**Your Ref:** OWPC13922  
**Our Ref:** R/64/17/PL 17-03-2017  
**Please ask for:**  
Mr D Easton

Demolition of 1 No. dwelling & erection of 4 No. dwellings. This application affects the character & appearance of the Station Road, East Preston Conservation Area.

St. Marys Close Hurst Road Rustington

Thank you for your internet representation made on 9th May 2017 which has been recorded as '**an objection**' with the comments as follows:

Drg No: 151117_SS-01 Rev: D

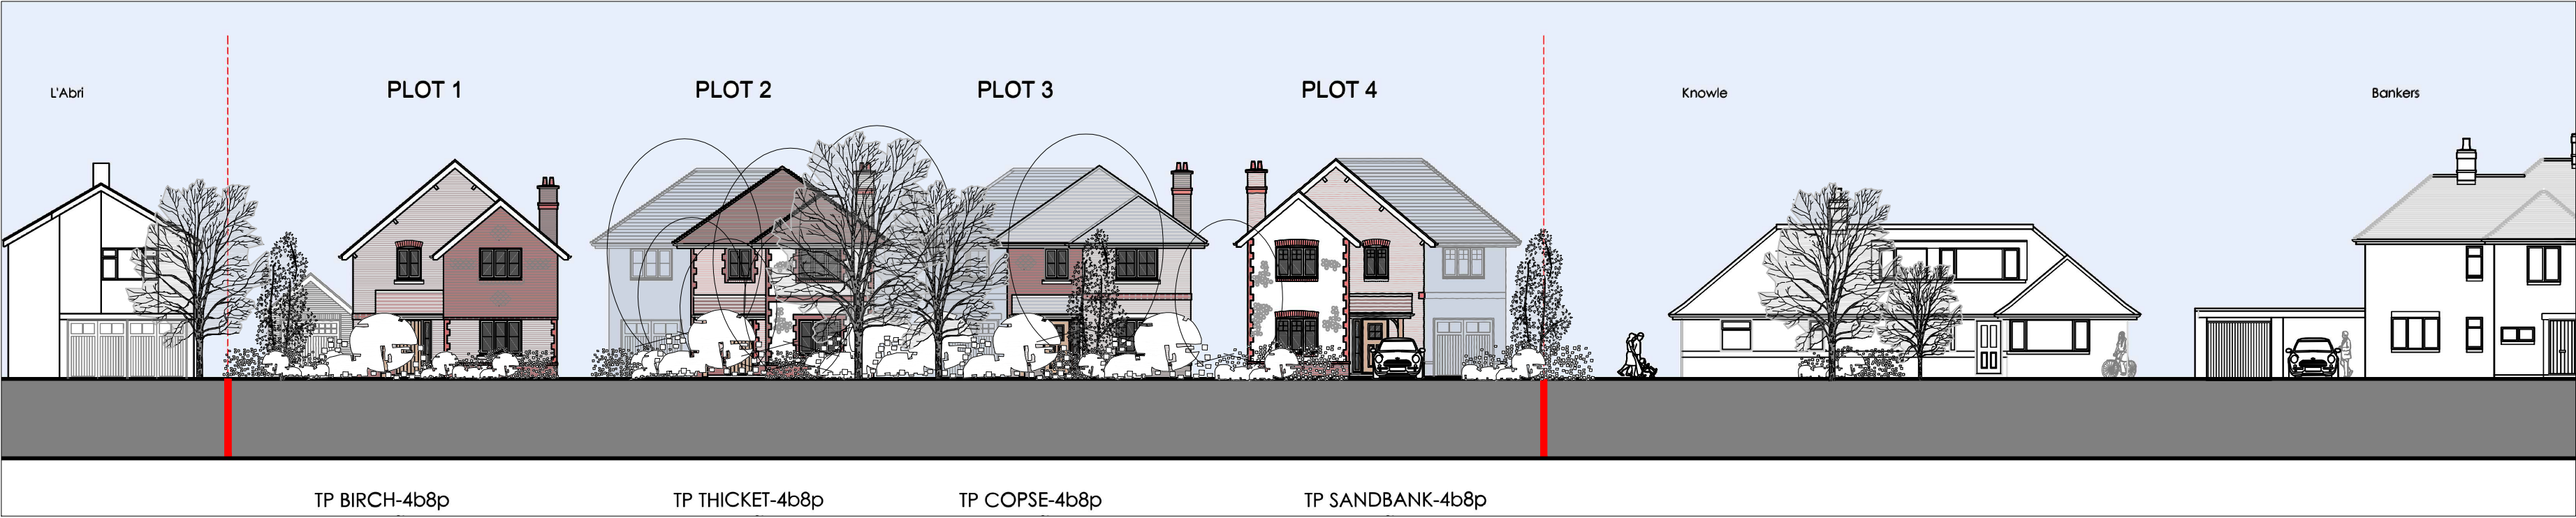
*1) Four houses compressed onto the St Mary's plot means great impact on the neighbours each side of the development; being too close together, as well as not being in keeping whatsoever with all the other properties in the road.*

*4) I was always under the impression that buildings were NOT allowed to encroach in front of the building line, and the plans show this to be the case with the 2 garage blocks.*
